# DEVELOPMENT HEARING OFFICER

**[PR-2024-010074](#)**

**VA-2024-00261** – Sidewalk Waiver

**REQUEST:** Waiver request to keep existing sidewalks at existing width

1 SITE PLAN
SCALE: 1" = 20'-0"

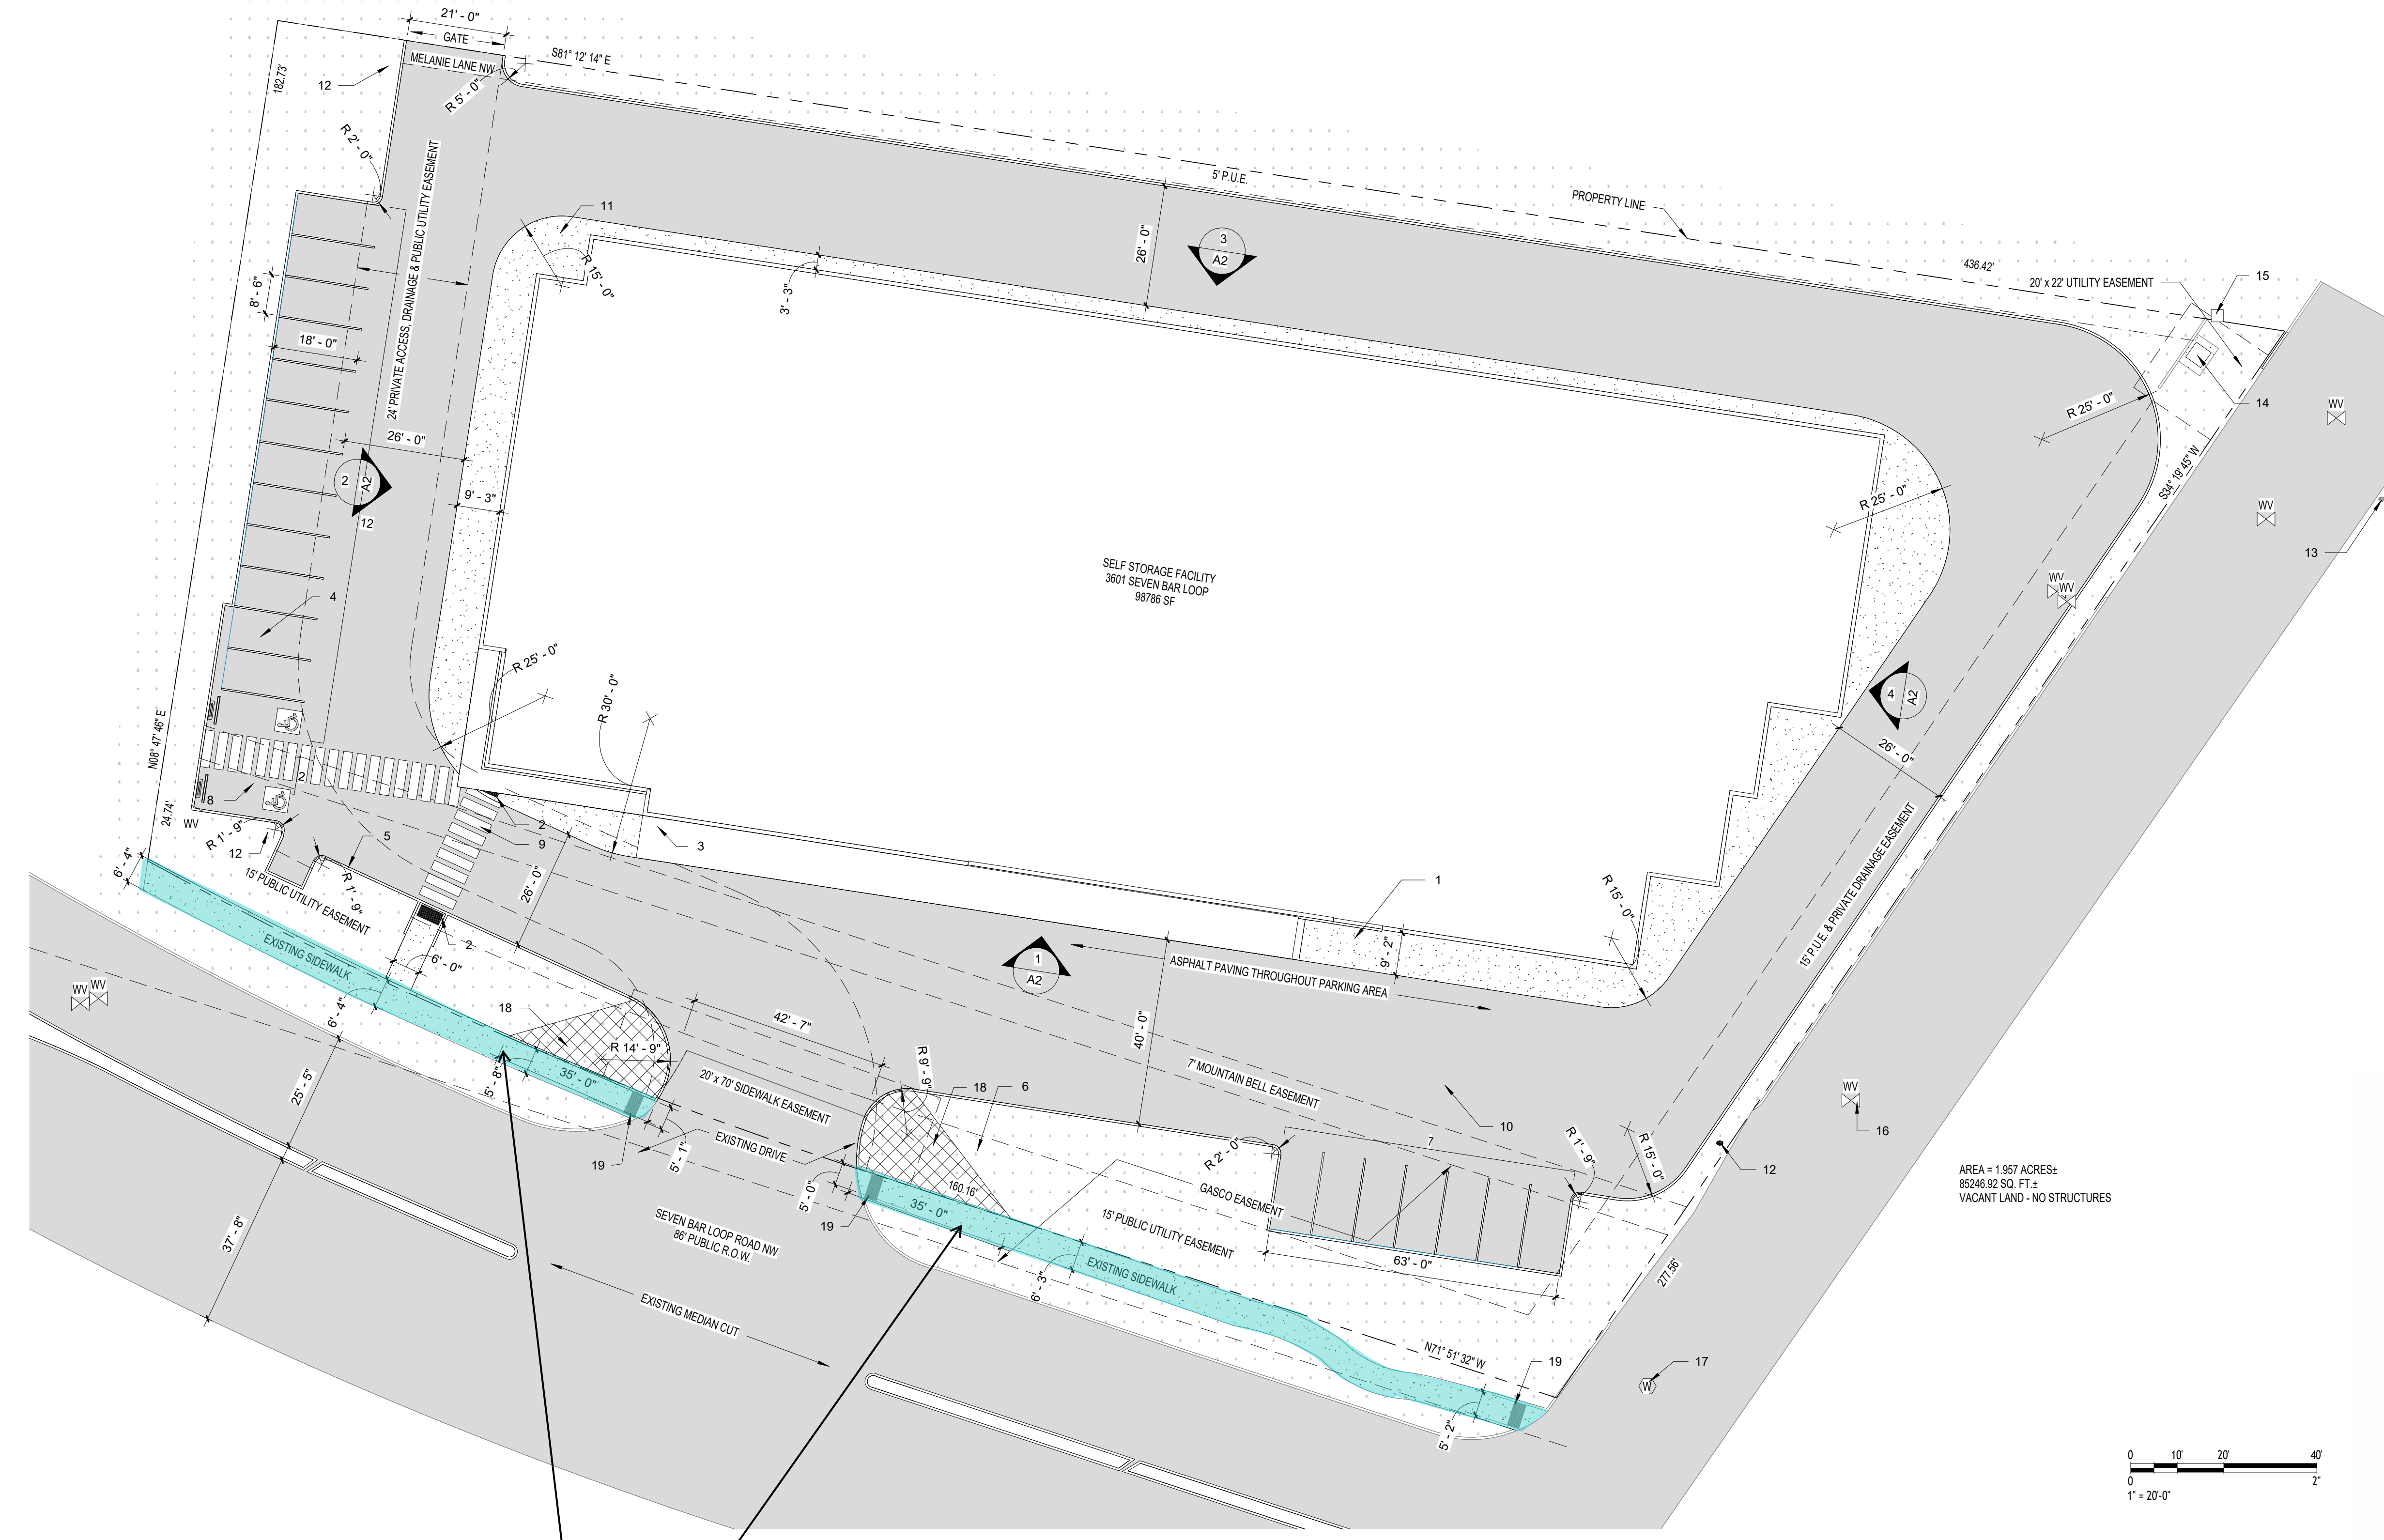
Per IDO 14-16-5-6(D) and the Street Tree Ordinance, street trees will be required along Seven Bar Loop Rd. Will the existing landscape buffer meet the requirements for Street Trees?

1. Seven Bar Loop is a Major Collector and a Major Transit Corridor within a Center and requires 10' to 12'' sidewalk with a 6' to 8' landscape buffer. In your waiver request you did not provide a dimension of the existing buffers along the frontage.
2. Transportation has reviewed the request for a waiver and does not find any compelling reason the sidewalks cannot be provided as required, as such Transportation is still requiring the 10' minimum sidewalk.

*Transportation has reviewed the request for a waiver and does not find any compelling reason the sidewalks cannot be provided as required; therefore, Transportation is still requiring the 10' minimum sidewalk.*

*Seven Bar Loop is a Major Collector and a Major Transit Corridor within a Center and requires 10' to 12" sidewalk with a 6' to 8' landscape buffer. Please provide a dimension of sidewalks and buffers along the frontage.*

- Clarify if the 6' to 8' landscape buffer is existing or will be a part of the Site Plan development.
- Project and application numbers must be added to any associated IL that would be attached to the Site Plan.
